WEST SUSSEX COUNTY COUNCIL CONSULTATION

TO:	Arun District Council FAO: Maria Tomalova
FROM:	WSCC - Highways Authority
DATE:	17 September 2020
LOCATION:	Bowley Farm Bowley Lane Chichester PO20 1NB
SUBJECT:	P/86/20/PL Retention of 4 No. mobile homes for countryside workers together with drainage & service connection provision in connection with permission P/72/09 as varied by P/22/017/PL. This application is in CIL Zone 5 (Zero Rated) as 'other development'.
DATE OF SITE VISIT:	n/a
RECOMMENDATION:	Advice
S106 CONTRIBUTION TOTAL:	n/a

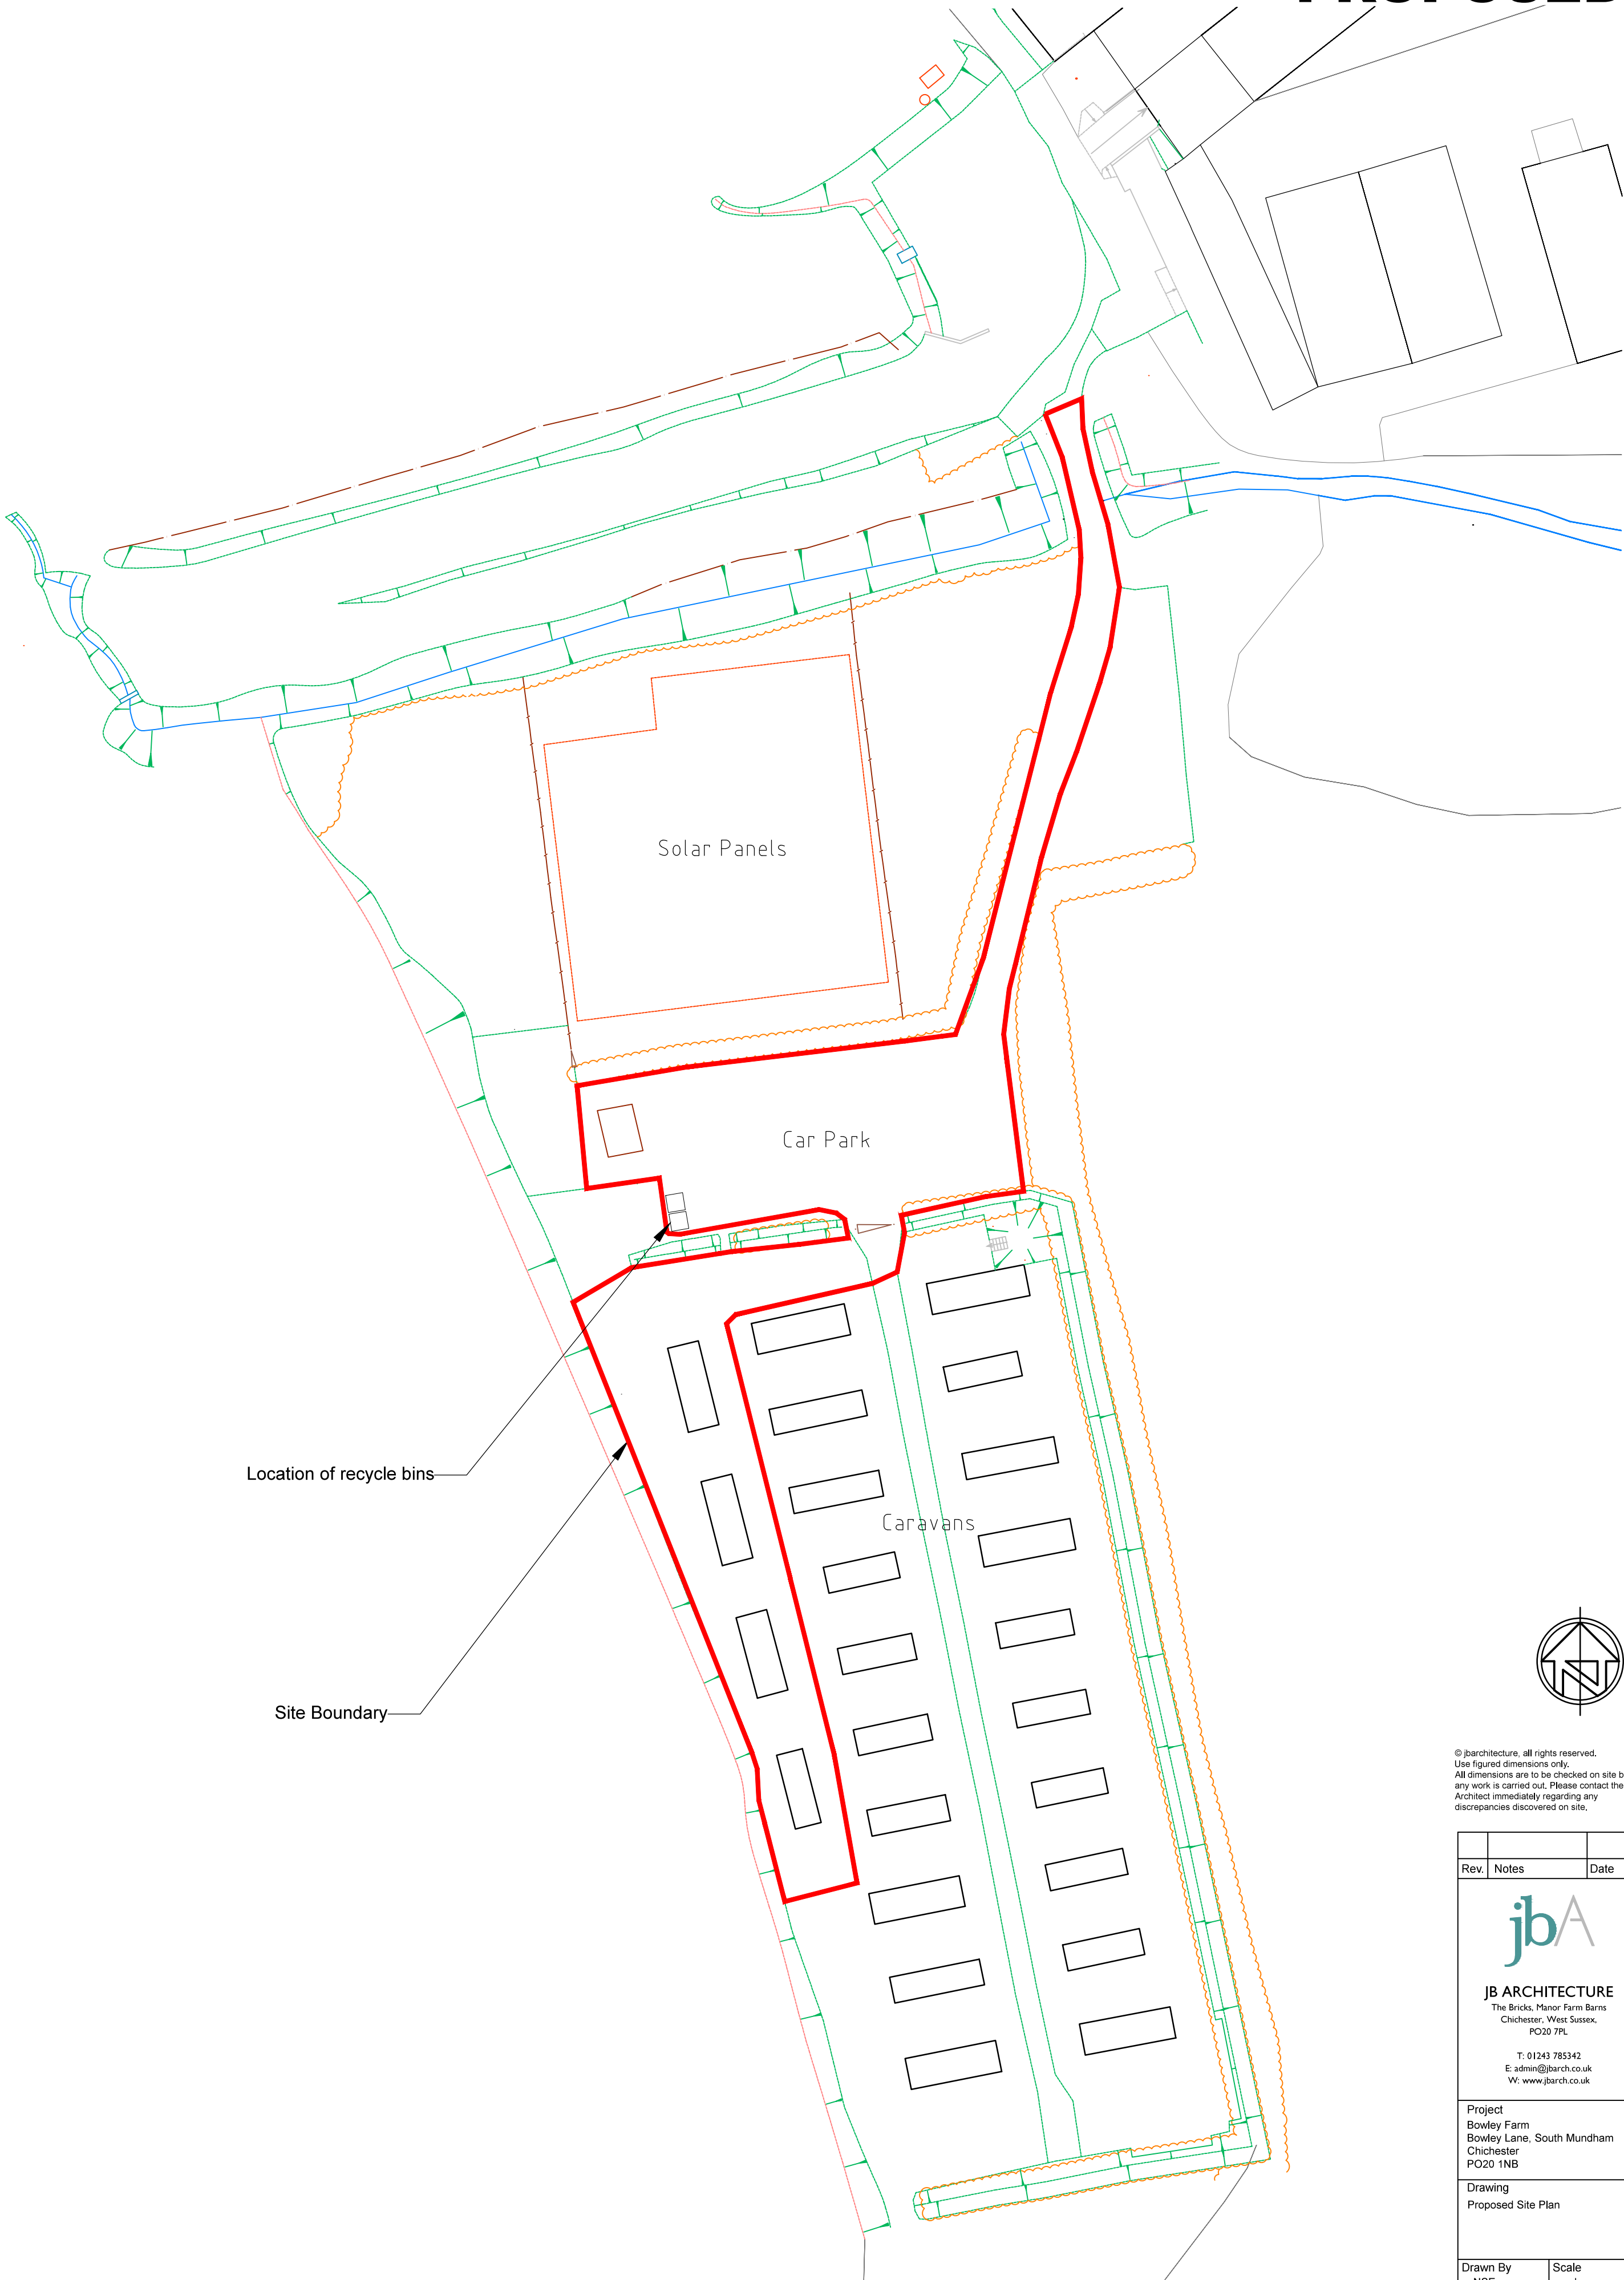
WSCC Local Mapping and the submitted plans show a hardstanding area located to the North (annotated as parking) large enough to accommodate any parking provisions of the site.

The applicant has proposed a NIL cycle parking provision, the LHA advises the Local Planning Authority (LPA) that if they deem cycle parking justifiable then the applicant should show this in the form of lockable covered storage. Details of which can be secured with a suitably worded condition.
